## Grounds for Objection

I am submitting this objection in relation to the proposed Battery Energy Storage System (BESS) and associated infrastructure within the Fenwick Solar Farm project. The following concerns are raised based on a detailed analysis of the Flood Risk Assessment (FRA) (Appendix 9-3) and Environment Agency (EA) climate change guidance as updated in January 2025.

### Formal Objection to the Fenwick Solar Farm Consultation

FIGURE NUMBER
Figure 9-3-6a

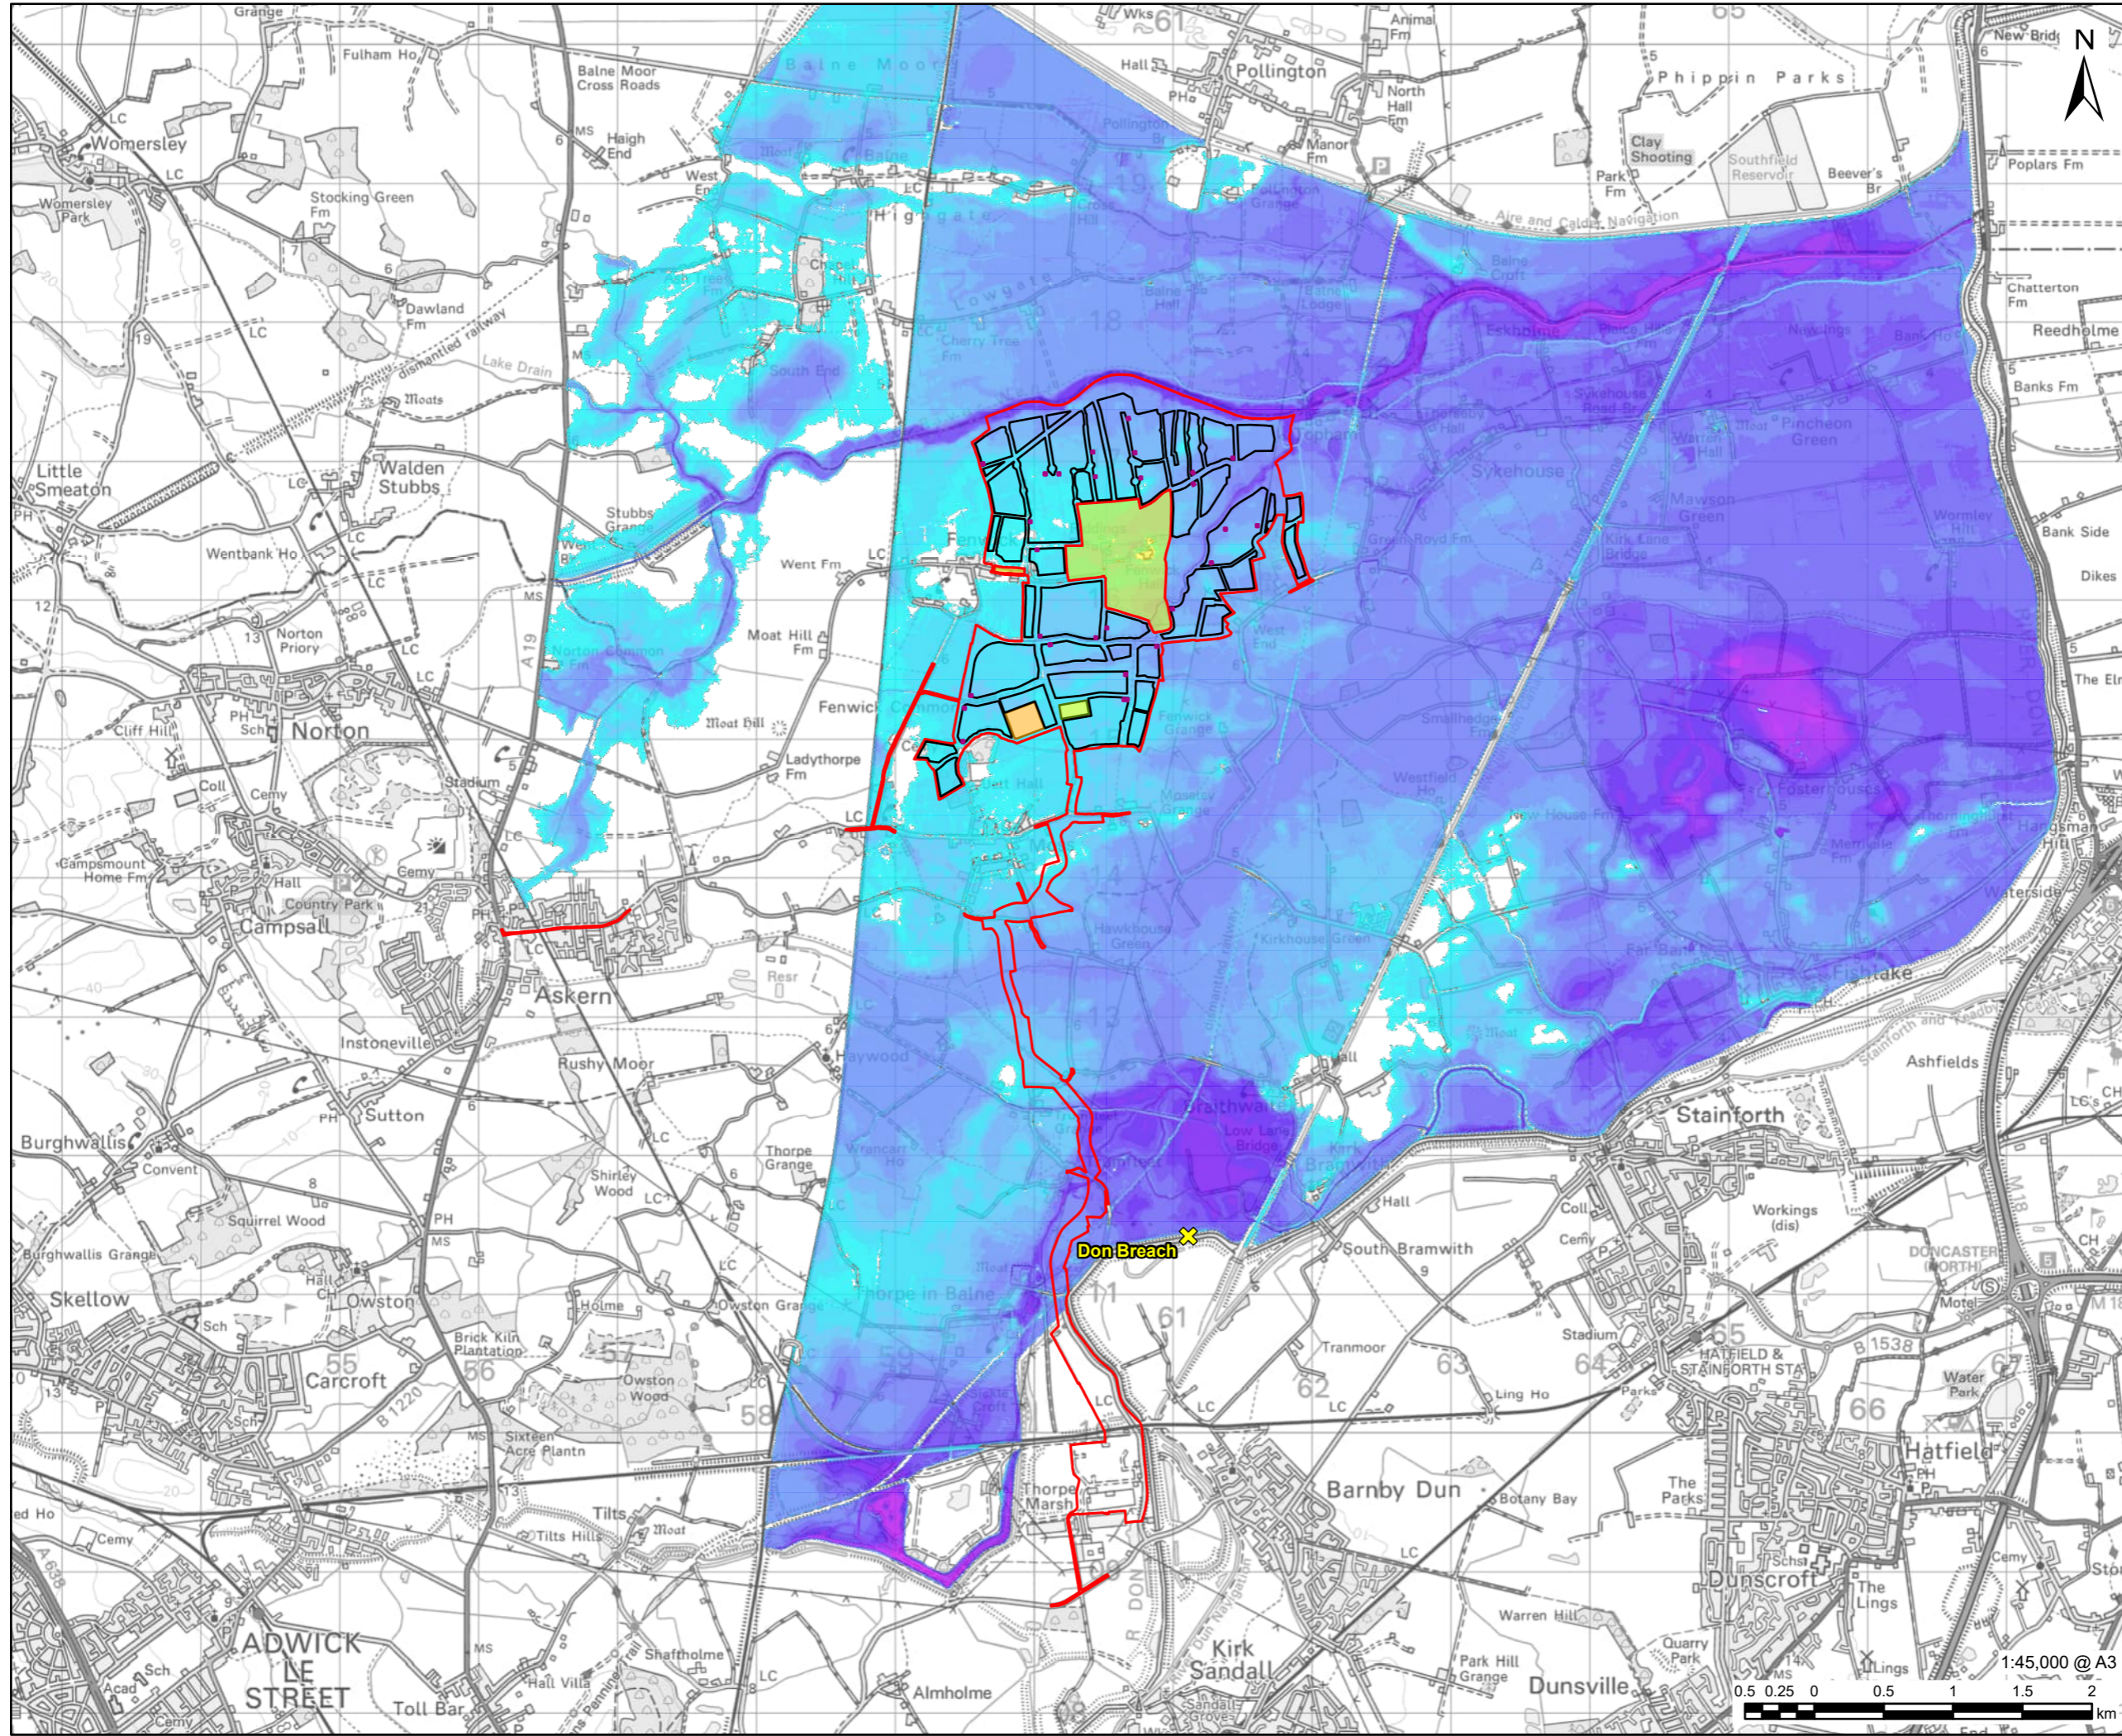
Although the developers claim the BESS is located within Flood Zone 1, the FRA identifies significant areas of the site as falling within Flood Zones 2 and 3. Furthermore, even in Flood Zone 1, the Environment Agency's breach modelling for the River Don indicates potential flood depths of up to 0.85m in the event of a failure.

This casts doubt on the site's suitability for critical infrastructure like BESS and substations, which

must be protected against both fluvial and residual flood risks throughout their operational life.

Plate 1: BESS Area Proposed Design

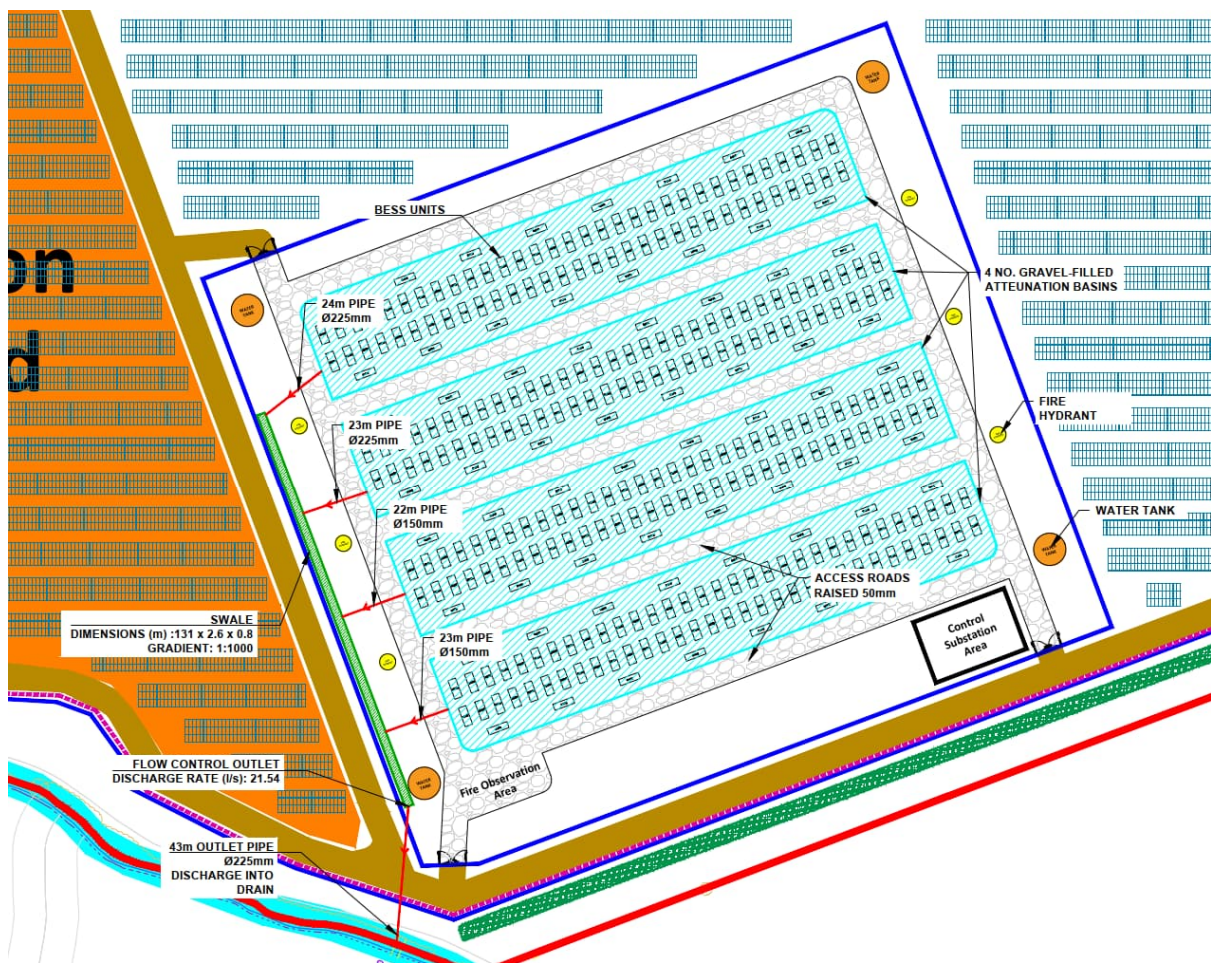
While the scheme includes bunds (e.g. 1.15m bunding for the BESS platform), these are based on outdated flood scenarios. The drainage infrastructure-including swales, attenuation basins, and soakaways-has been designed using lower rainfall assumptions. This leaves the site vulnerable to increased runoff volumes and flood depths under updated EA projections.
